# An Bord Pleanála Opinion Response Report (Architectural Items)

**THE FARM**  
BESSBOROUGH  
BLACKROCK  
CORK

**MARCH 2022**

This document addresses the principle ABP ( An Bord Pleanála) opinion items as set out in the Boards opinion issued in December 2021 that concern Architectural specific responses . Note other response items are addressed across other design team disciplines reports.

BUILDING C

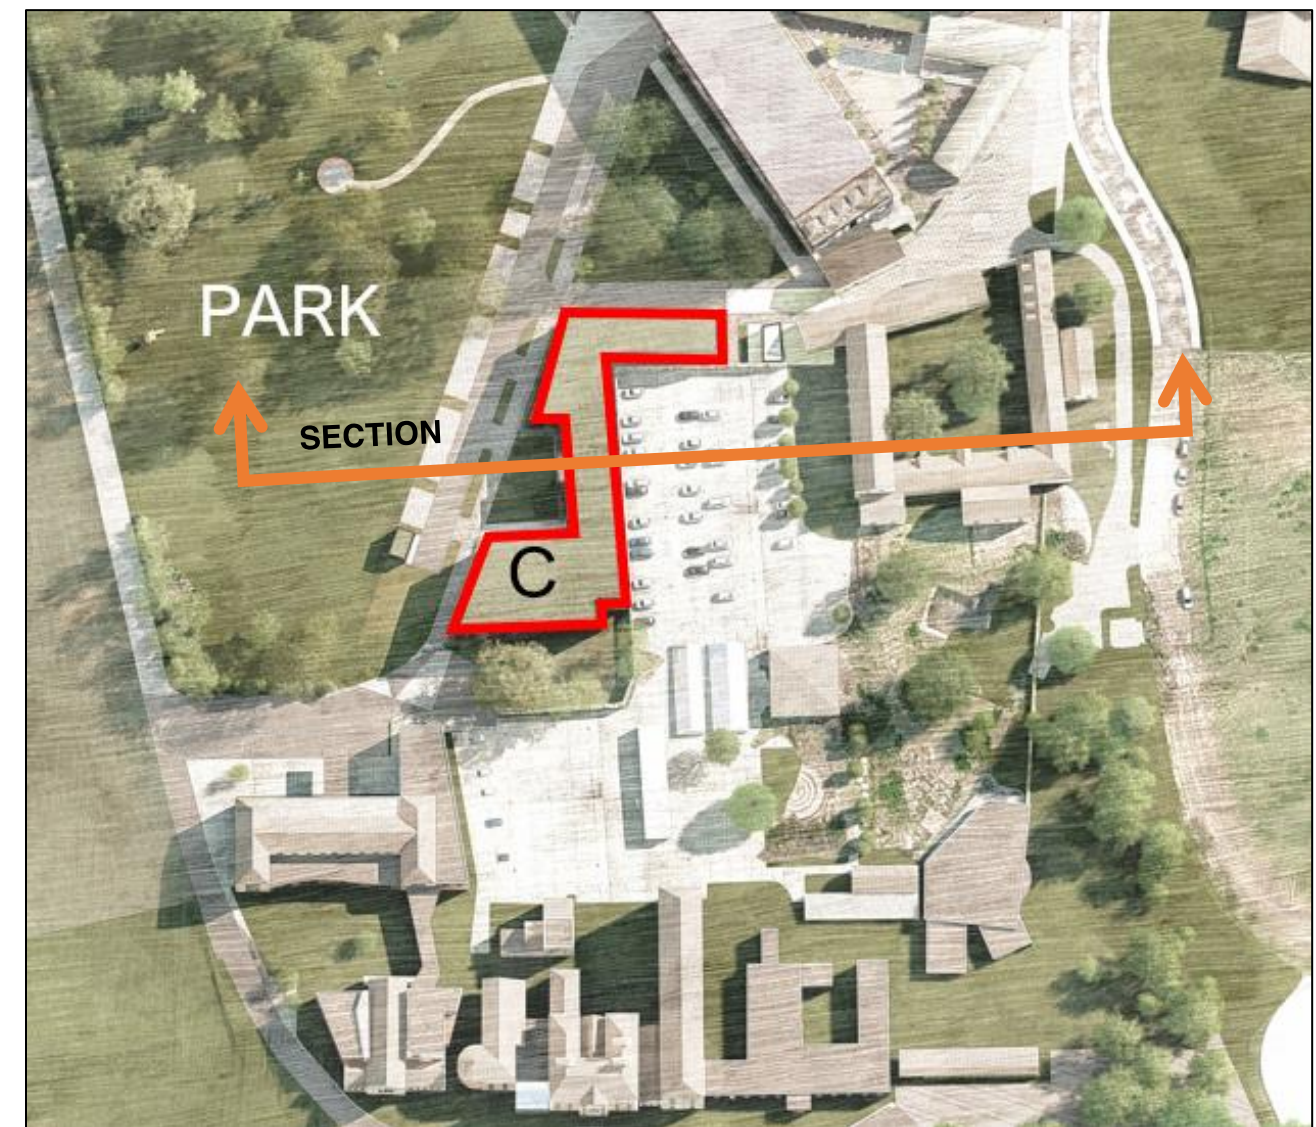
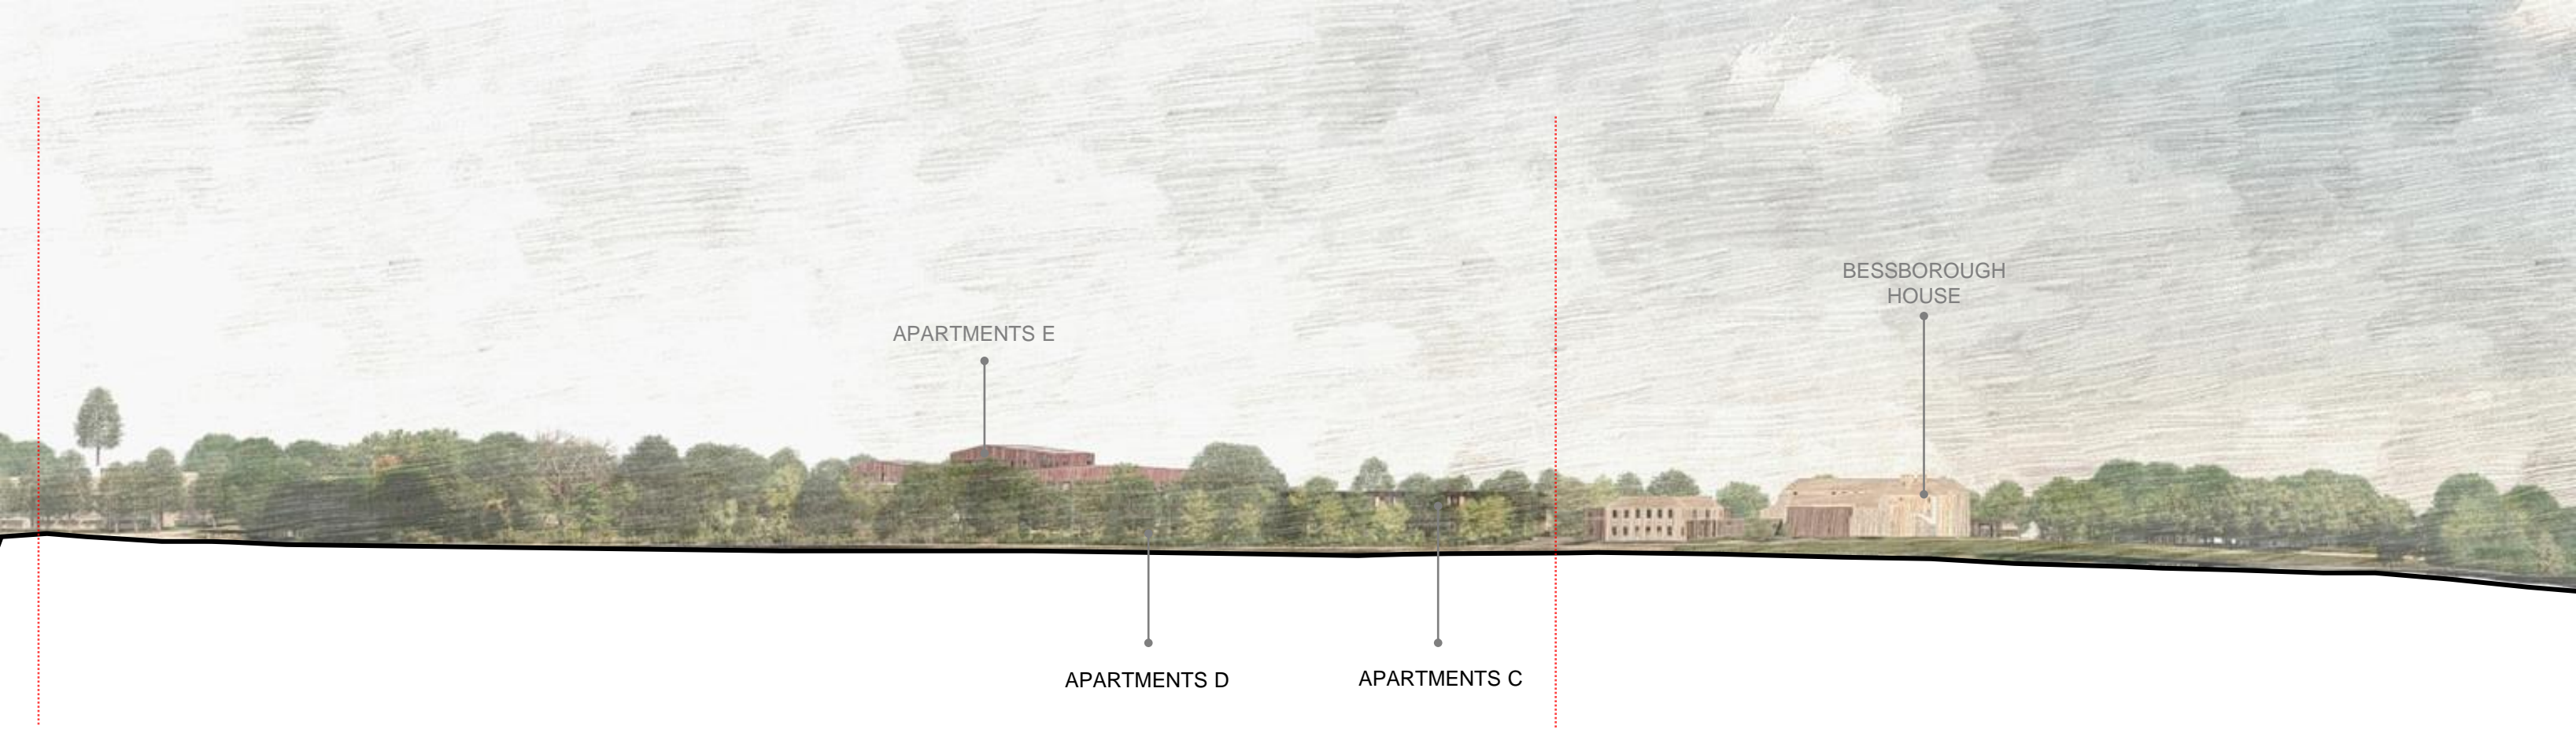
'...The original Bessborough House and Estate had farm buildings and associated plots to the north-east area of the estate and the remainder of the estate was parkland. The proposed development are apartments within a park setting, four to six storeys in height and have minimal relationship to the park. Block A should be omitted, and Blocks B and C relocated and reconfigured to form an edge to this parkland in association with the farm buildings.' – City Architect.

The adjustment is incorporated in the new building C which is 'reconfigured to form an edge to this parkland' while also reducing in scale significantly to 3 storeys in height. This also supports the zoning objective by provision of the former main access from the house to be highlighted (yellow) with a clear edge to the East. Consequently with this alteration and redesign the landscape benefits are clear in the retention of the primary open space of the park setting while additionally giving an historic route more definition and clarity.
